CONSERVATION AREA ADVISORY COMMITTEE

Comments on Planning Application no AB/77/17/PL - 45 sheltered apartments for the elderly, Blastreat Ltd and Greenhurst, Fitzalan Road, Arundel

Side Elevation (West)

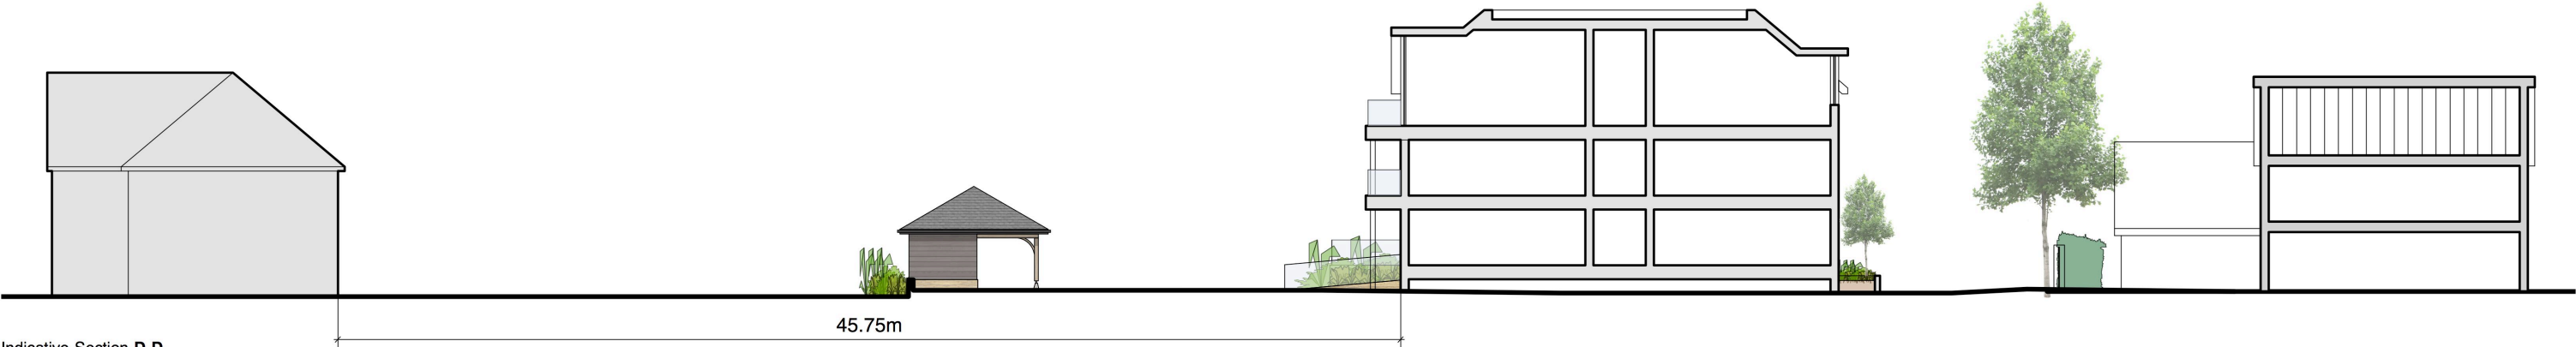
- (2) In general, the scheme represents an overdevelopment of the site. It is essentially 2 massive, oversized boxes onto which subsidiary elements such as gables and dormers are attached. Together with the false pitch roofs and poor elevational treatment, particularly on the red brick section, the design falls well below the quality which should be expected and required on the edge of a nationally important conservation area.
A much more sensitive design approach needs to be followed of legible building forms, including fully formed roofs, and a variety of heights, depths and lengths of building, used in such a way to reflect the different character of Fitzalan Road between the south eastward leg (urban) and the south westward leg (suburban).
High quality finishes, detailing and materials should also be required since they are not evident on the plans or in the Design and Access Statement.
